Project# 1004976

BORDENAVE DESIGNS agents for CALABACILLAS GROUP request the referenced/above actions for the P.U.E. on, and a portion of GOLF COURSE RD NW adjacent to, Tract A-1-A-1 **BLACK ARROYO DAM**, located on the west side of GOLF COURSE RD NW between WESTSIDE BLVD NW and the CALABACILLAS ARROYO containing approximately 8.0350 acres. (A-12)) [Deferred from 4/23/14, 5/7/14, 5/21/14]

Ref: Response to Review Comments May 15th DRB meeting- 13EPC 40091- HME Healthcare-
Westside and Golf Course

DEVELOPMENT REVIEW BOARD – SPEED MEMO

ALBUQUERQUE, NEW MEXICO  
 APRIL, 2014

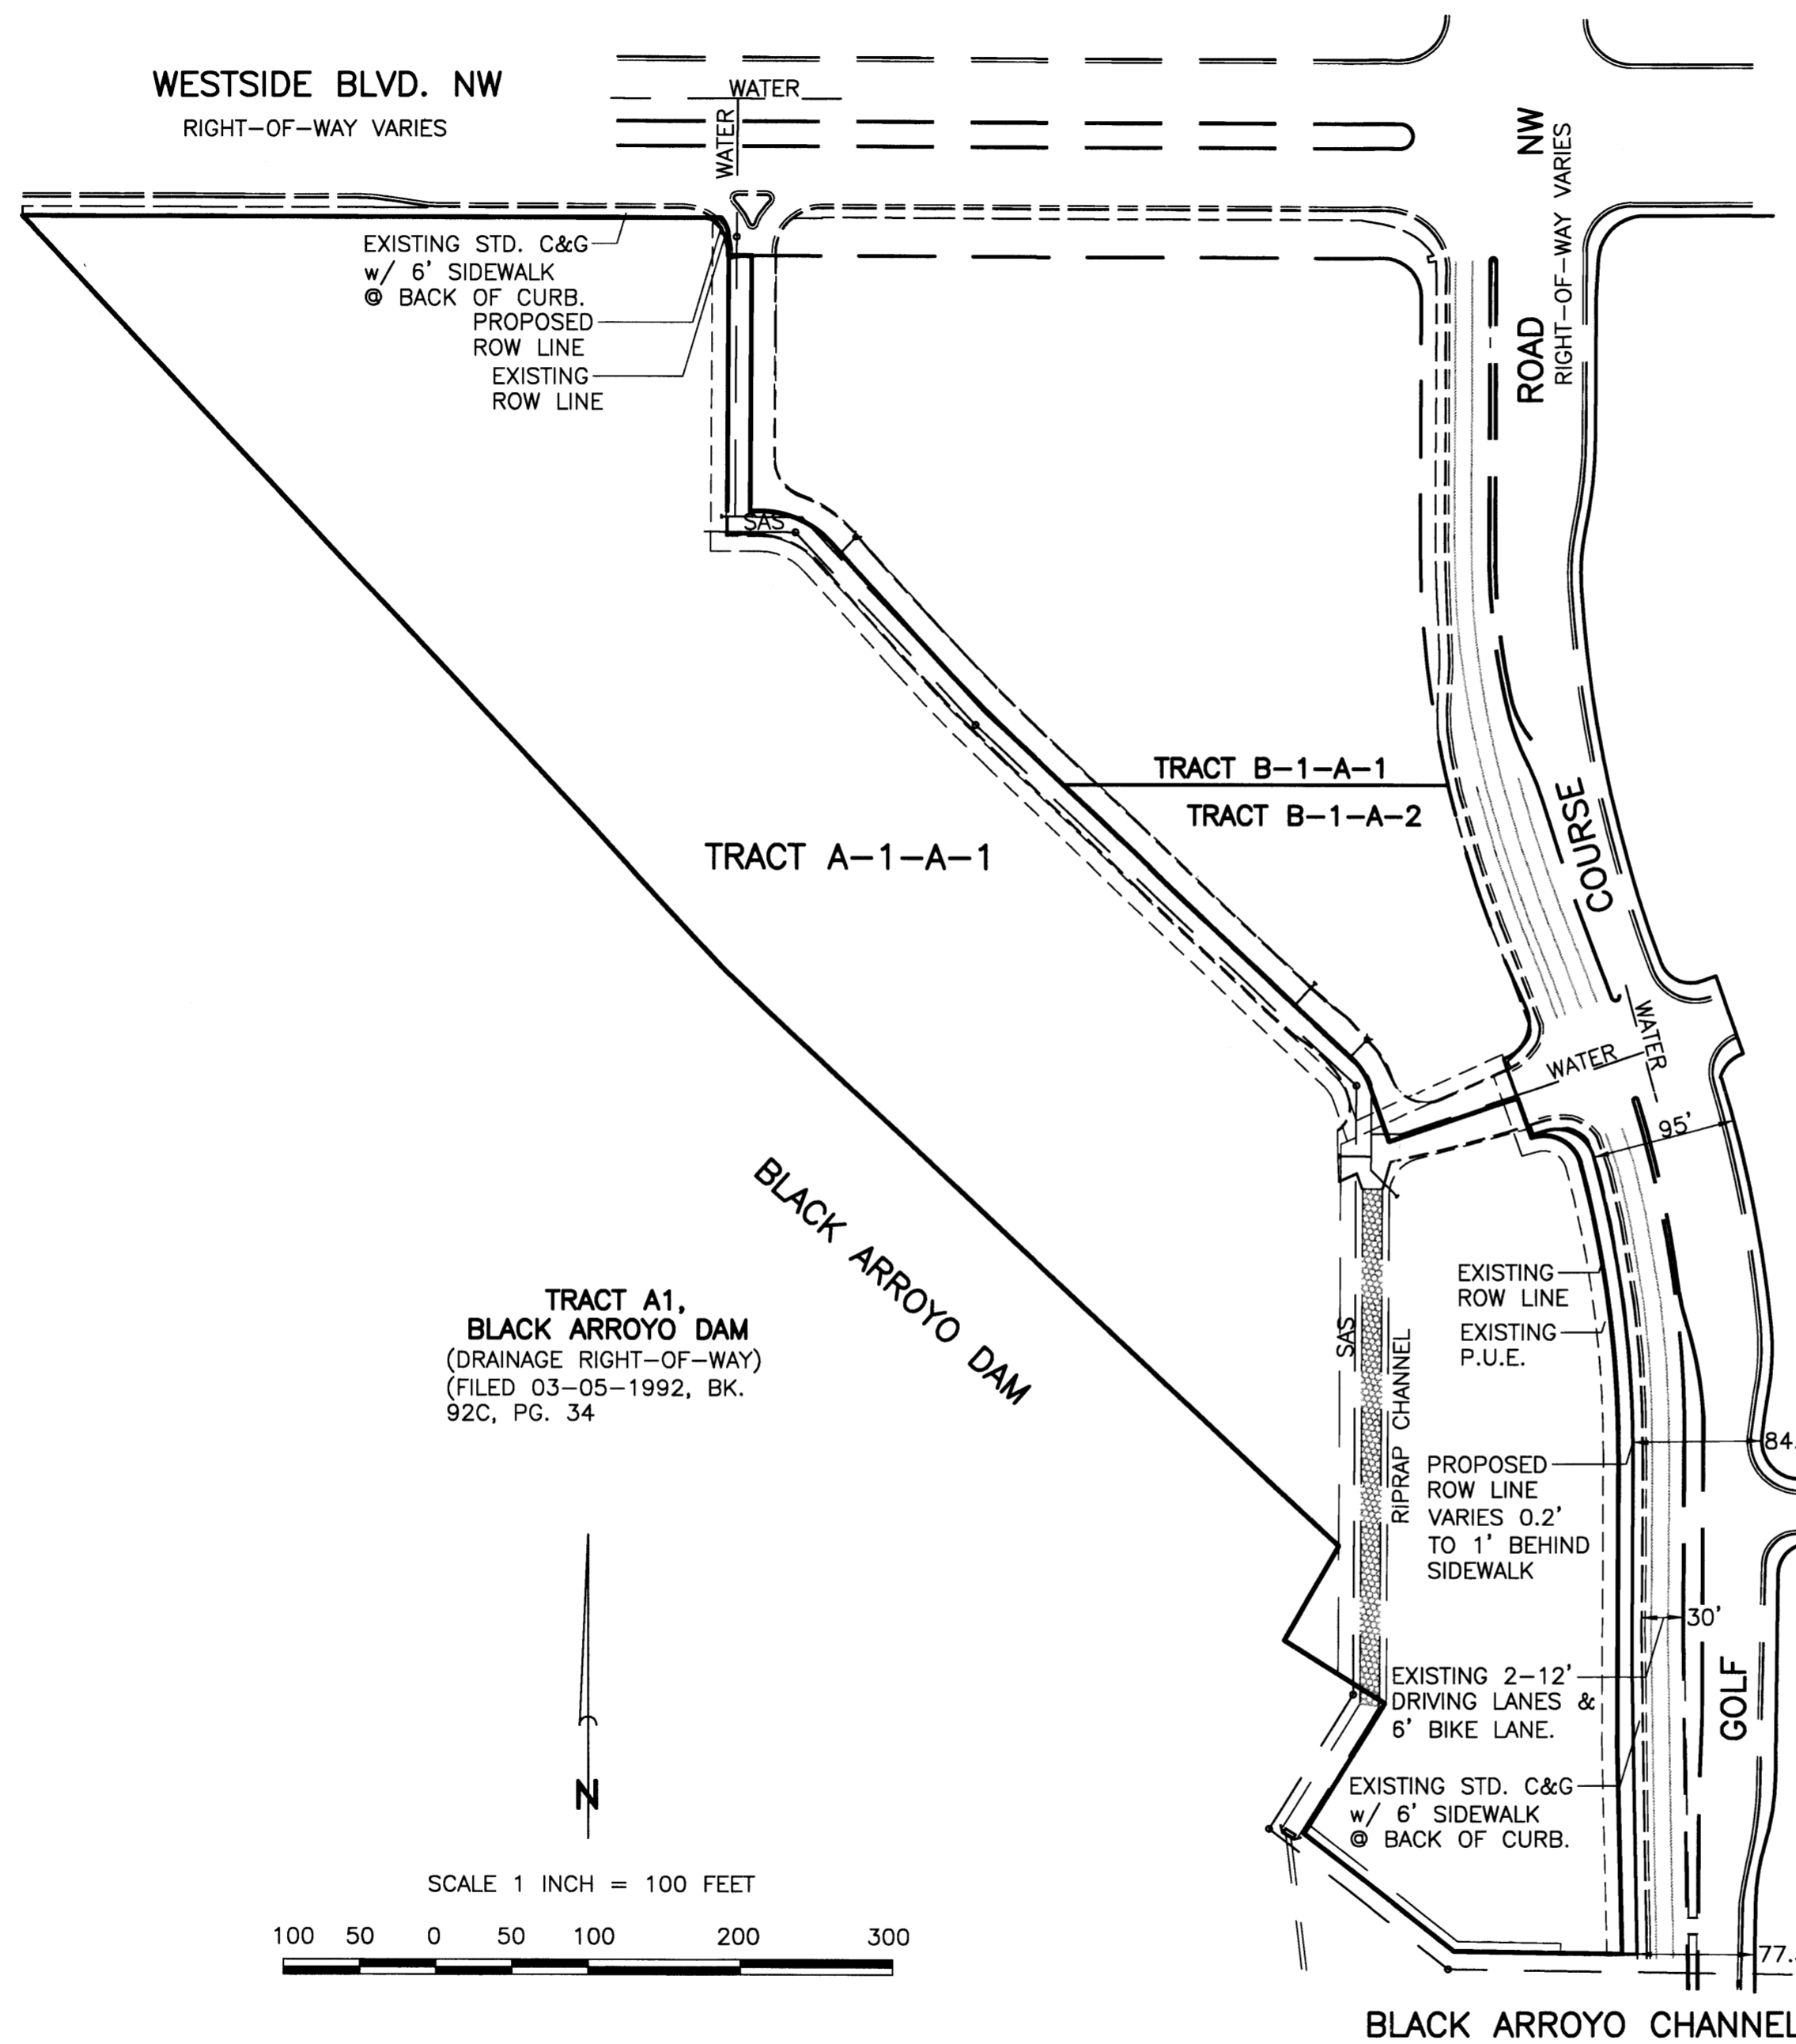
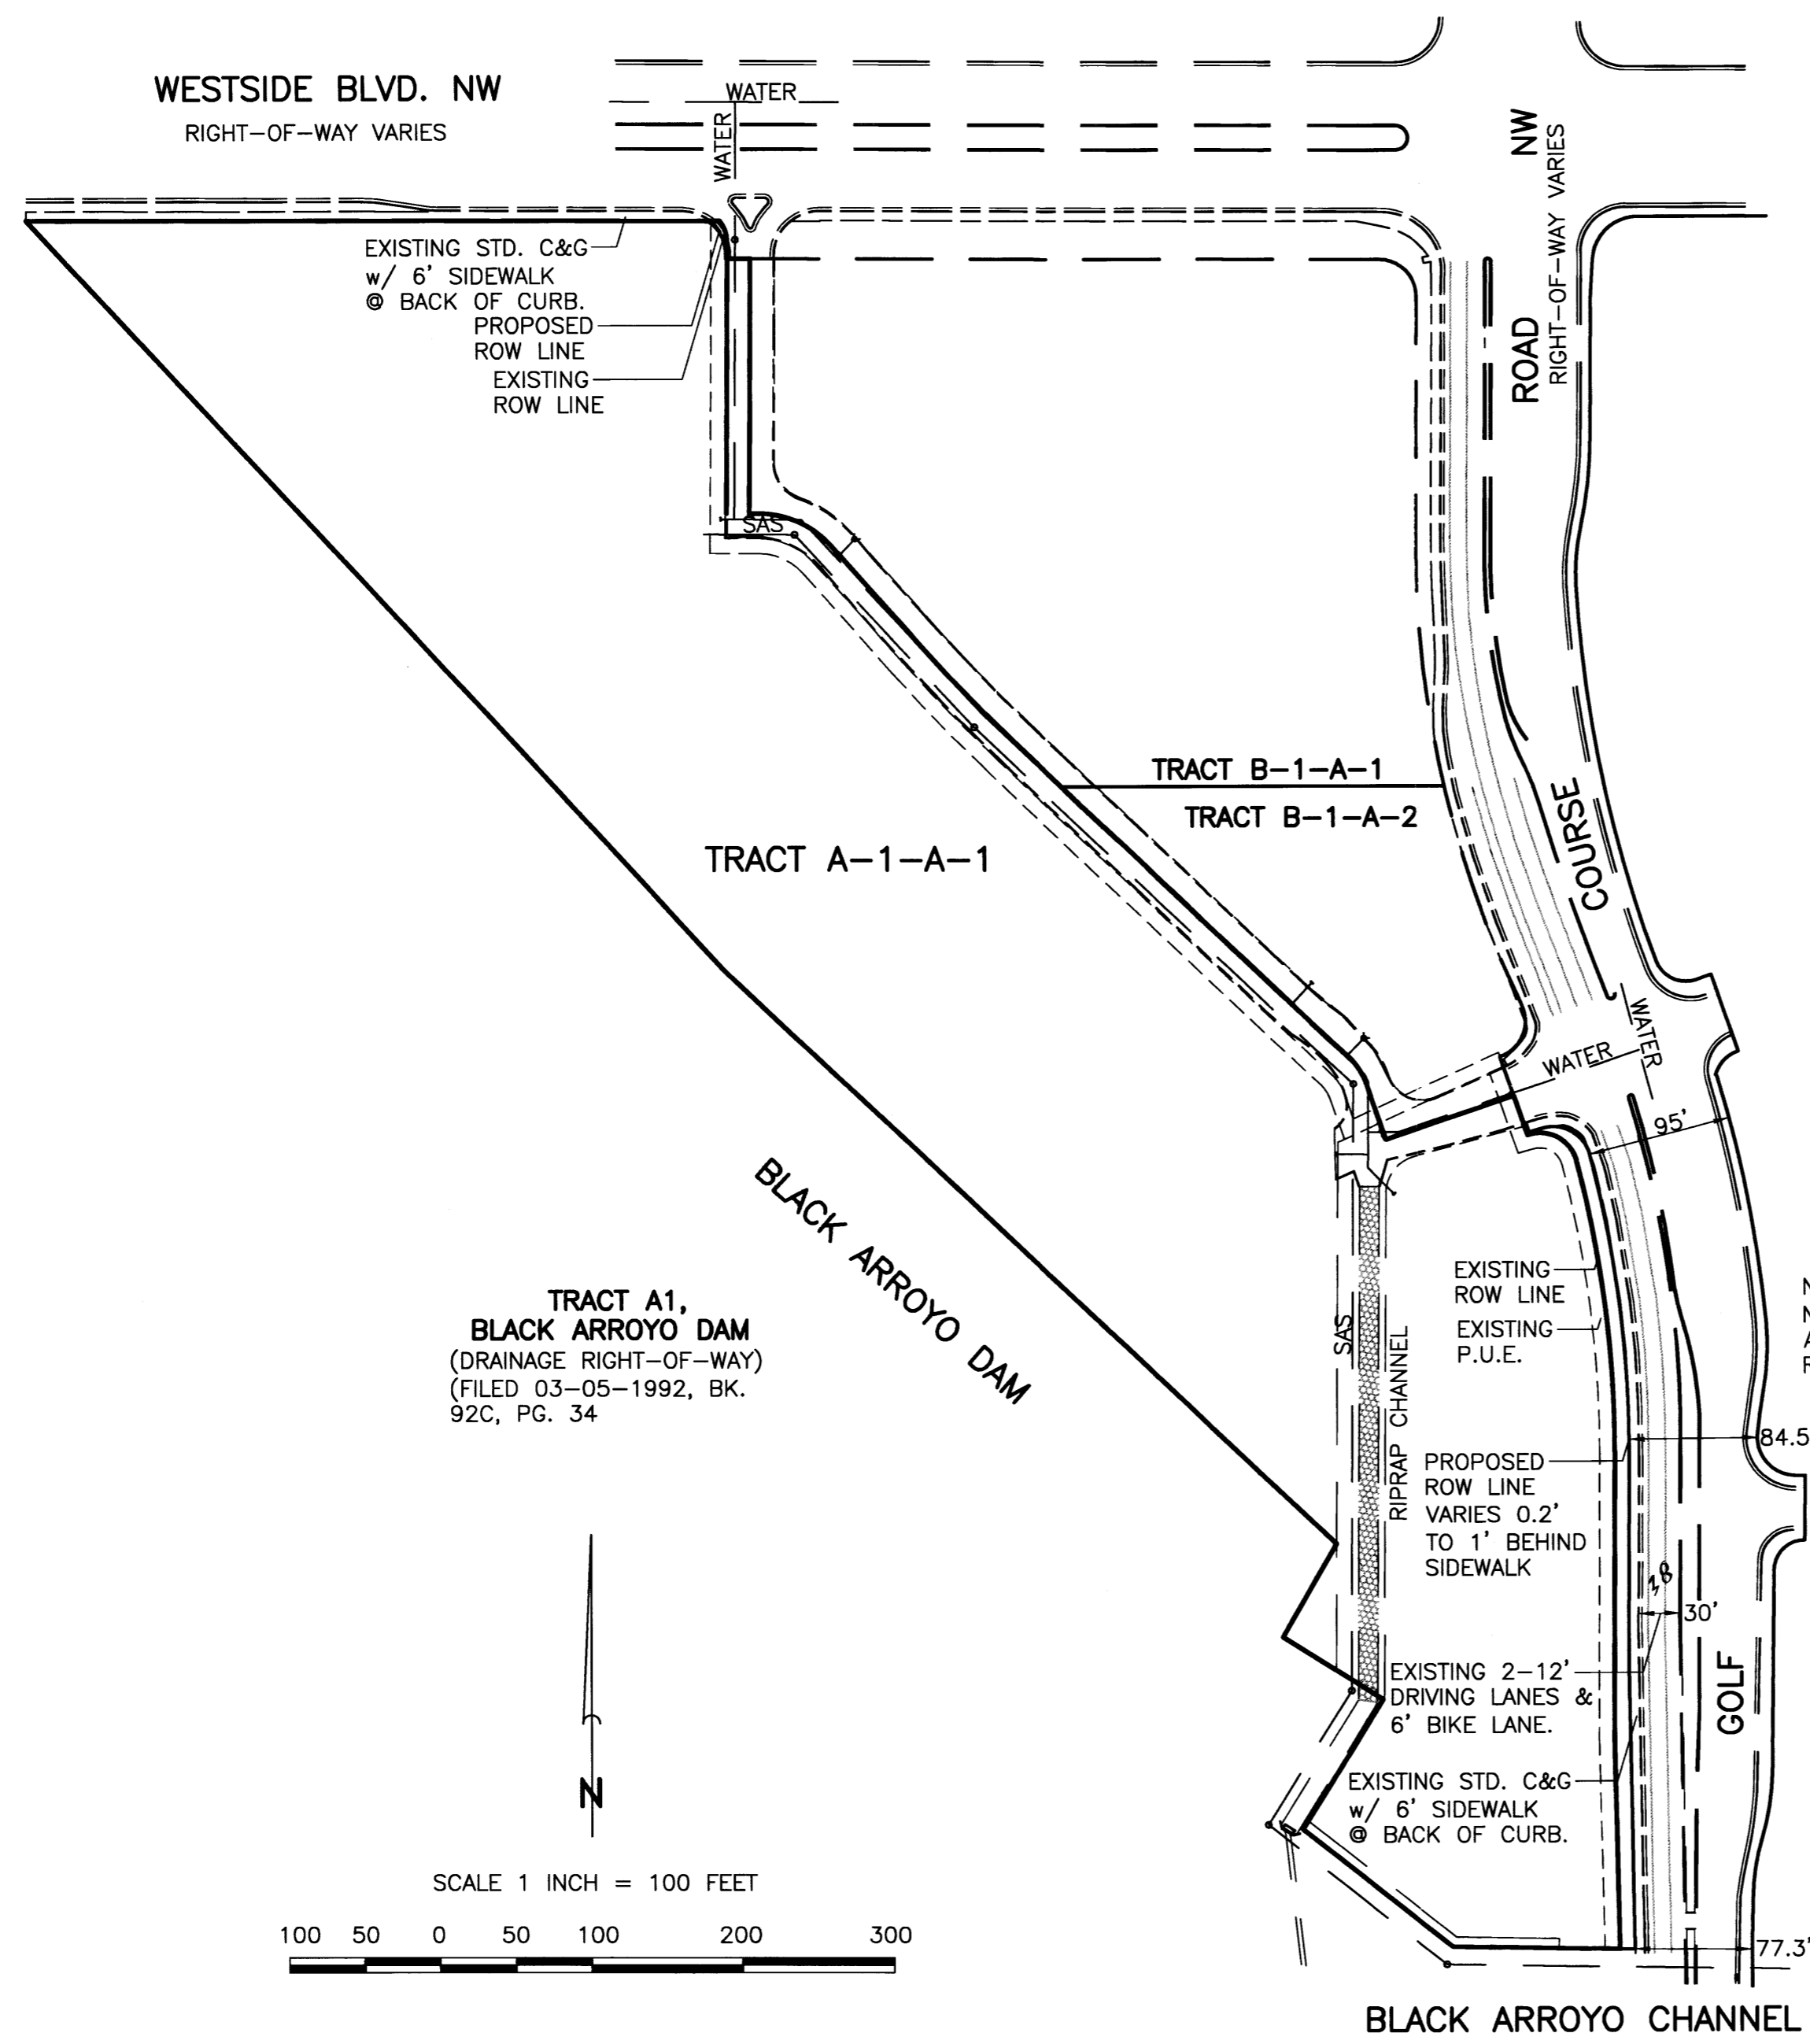
An application for a Subdivision Design Variance must be made to support the vacation application. Call out dimensions and indicate total R-O-W and pavement widths, both existing and proposed. The exhibit must include dimensions for the existing plus proposed distances from back of curb to property line.

The submittal letter notes a previous vacation on the east side; however, a review of the file 1002556 does not show a vacation across from the current request but instead a dedication for a deceleration lane. The distance from back of curb to property line is noted as 10 feet; this was adjacent to a deceleration lane. Additional information must be provided.

At the April 14, 2014 Development Review Board meeting, the vacations were approved to allow the property line to be 10 feet behind the curb per the DPM per section 14-14-7-2(a) (1) and (b) (1)(3) of the subdivision ordinance. A subdivision design variance from minimum DPM design standards was approved as shown on the applications and exhibit in the Planning file
